CITY OF ALBUQUERQUE

June 3, 2015

**Re: 17 Unit Townhouse Development
1120 Griegos Rd NW
Grading & Drainage Plan (F14D058)**

17 UNIT TOWNHOUSE DEVELOPMENT GRADING AND DRAINAGE PLAN

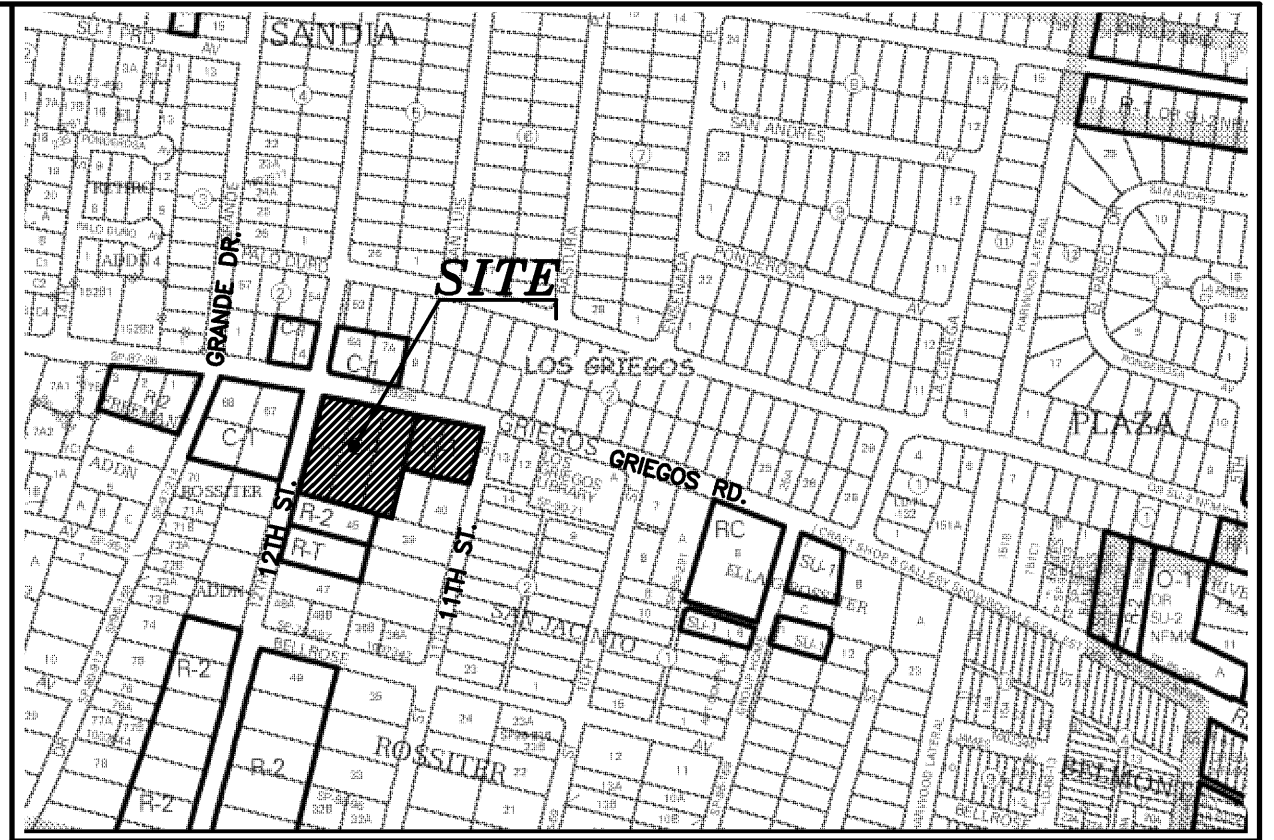
- Provide the roof flows.
- Label turn blocks at each wall or state typical opening for drainage.
- How are the flows handled to the east of this site?
- Extend the sidewalk culvert 1 foot passed the property line.
- An ESC plan is required and accepted by Curtis Cherne before BP approval.
